FINAL DRAINAGE LETTER
FOR
LOT 35, CLAREMONT BUSINESS PARK
FILING NO. 2
EL PASO COUNTY, COLORADO

OCTOBER 2017

Project #44-029
PCD Project No. PPR-17-000

PPR-17-056

**CONSTRUCTION NOTES:**

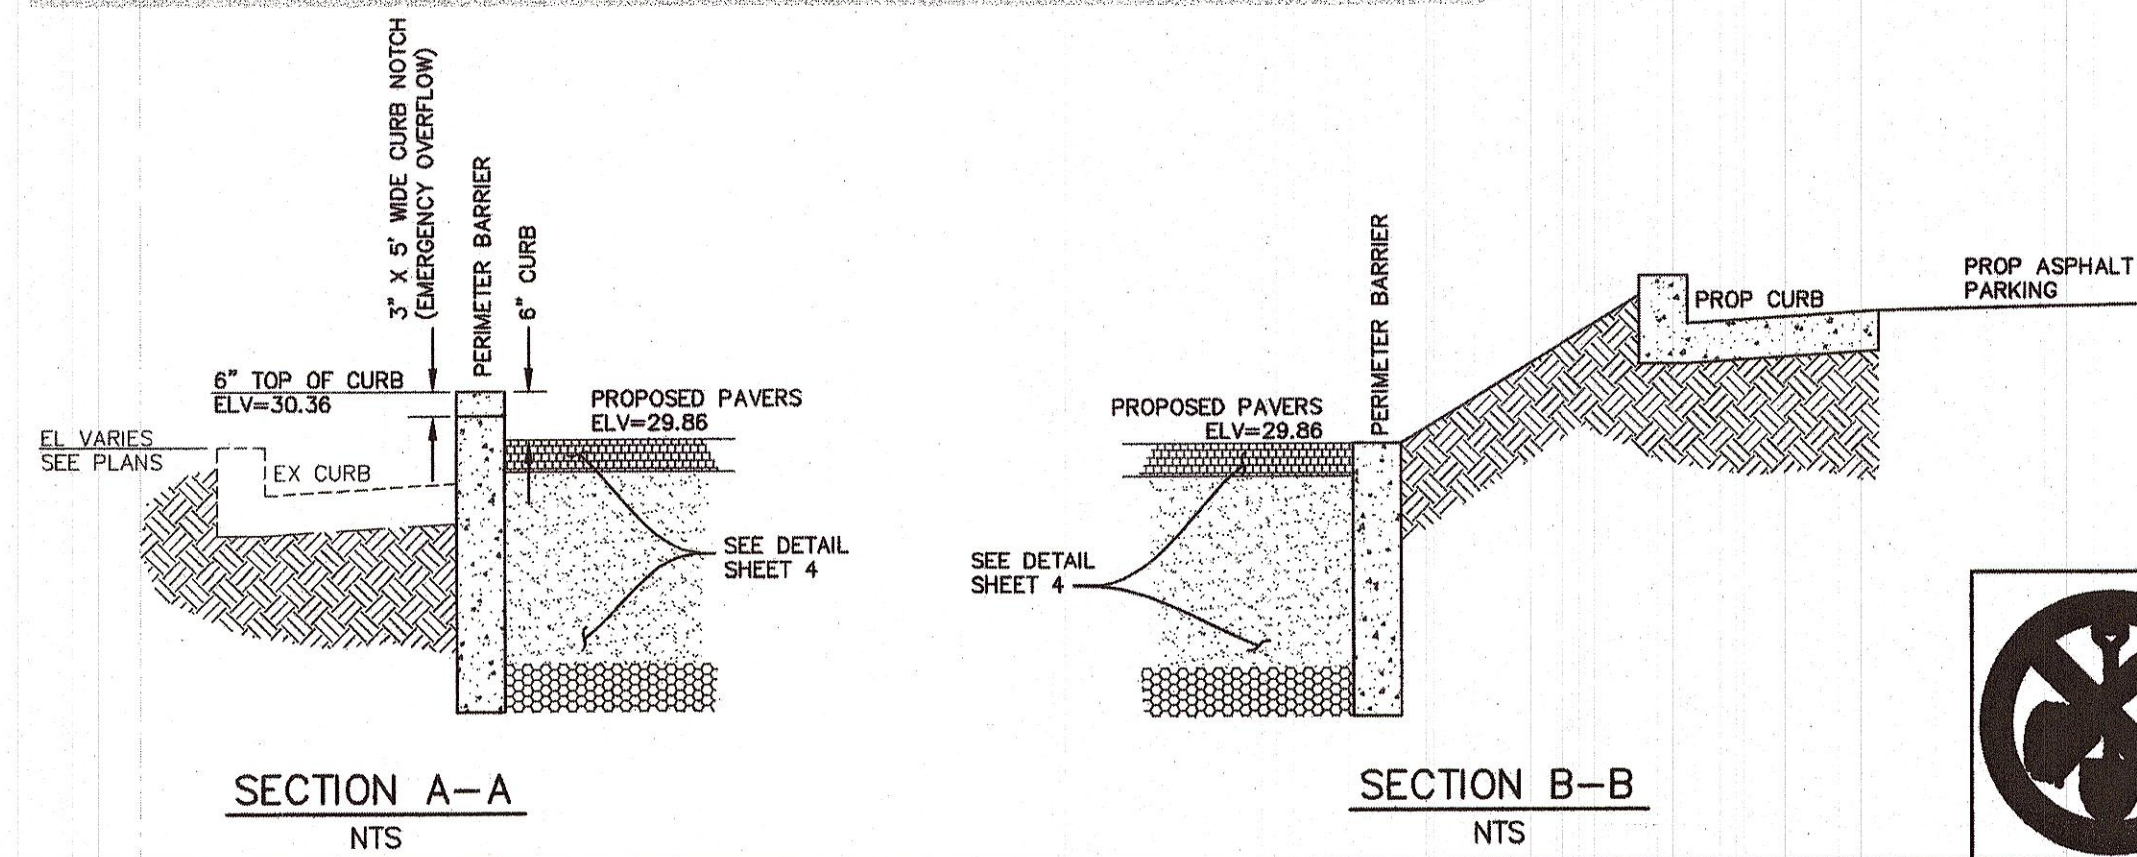
Add these notes in the GEC plan set.
